Case Reference Number: PAX19.324161 at Lemaghan and surrounding townlands, Co. Offaly (www.lemanaghanwindfarmplanning.ie) Proposed development of 15 no. wind turbines, a permanent 220kv on-site substation, and associated infrastructure.

I hereby submit my observation regarding the above Case Reference.

Plate 6 View north-east along Togher OF015-084— within the Derrynagun Bog captured from a drone to the east of the Lemanaghan Monastic Complex: Annotations have been added to the aerial image to identify the togher and direction of other relevant features

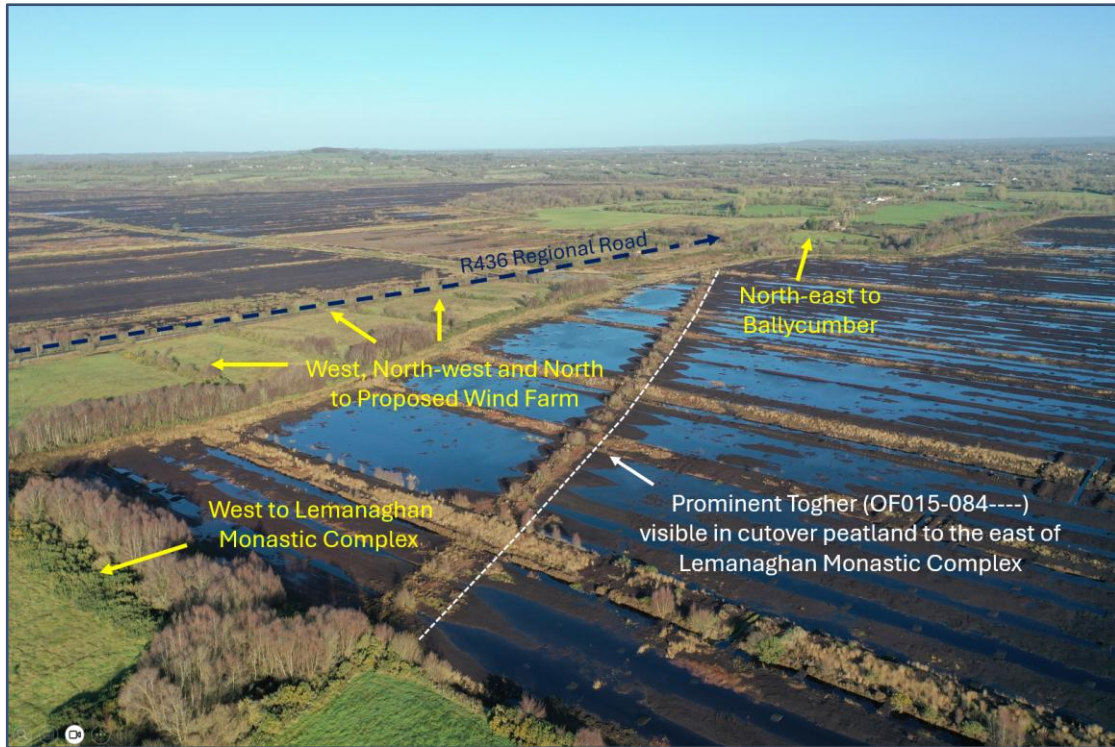
[Photomontage VP14](#) states that Mella's Cell is 1.28km from the nearest Turbine (No. 14). Again, all the photographs seem to be taken from a similar angle to try and mask the impact of these proposed turbines. The images are taken from the same area (corner) of the Cell, and do not reflect what the reality of the situation will be if the proposed wind turbines are given permission.

When one walks from Mella's Cell, up the Togher, to the Holy Well and Monastery, they will have full view of all of the Turbines. This will have a detrimental effect on the "peacefulness and serenity" of this walk, which is a very important part of the experience of visiting the site.

Figure 1-7 Zoomed view of County Offaly 2021 Amended Wind Energy Zoning highlighting location of turbine T05

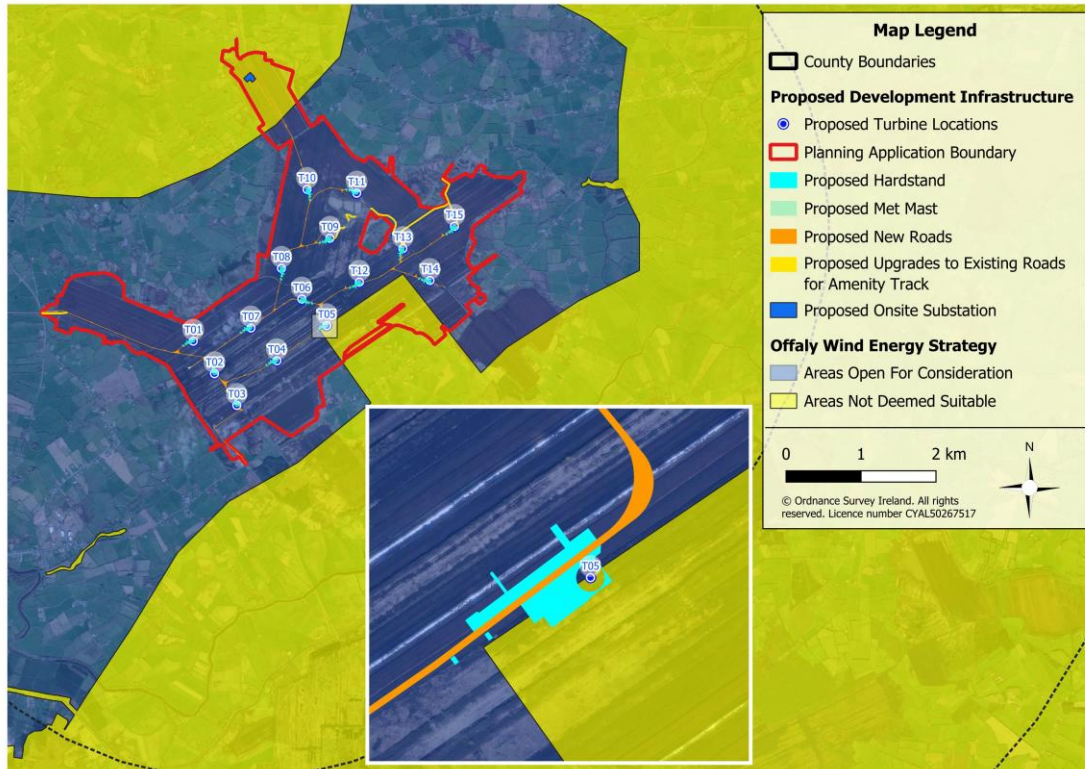
The Planning Report acknowledges *Section 3.2.3.3.1 Suitability of Lemaghan Bog of Chapter 03 Site Selection and Reasonable Alternatives* that Turbine T05 “is located on the boundary of an area designated not deemed suitable for wind energy developments” in the [*Offaly County Development Plan \(OCDP\) 2021 – 2027*](#). The SID designation means the application bypasses Offaly County Council and goes directly to ACP. This does not mean that ACP can ignore development plan policy. Under section 37F of the Planning and Development Act 2000, ACP must have regard to the development plan when determining a SID application.

This particular turbine (no 5) is the turbine that is being placed on the “area deemed unsuitable for wind farm” by Offaly County Council. A total of 157 houses will be affected by shadow flicker. This is a huge number of families that are expected to endure shadow flicker for the life of the windfarm. The report suggests that they will programme the system so that the respective turbines could be “turned off” for the times that the shadow flicker will exceed the threshold times for 58 of those houses. Do they really expect us to believe that? They have the nerve to suggest that blinds can be purchased for the rooms of the houses that are affected by shadow flicker, or a hedge could be planted. These are unbelievable “solutions” that they propose. We are country people. We live and work out doors most of the time, and cherish the beautiful lands that surround us.
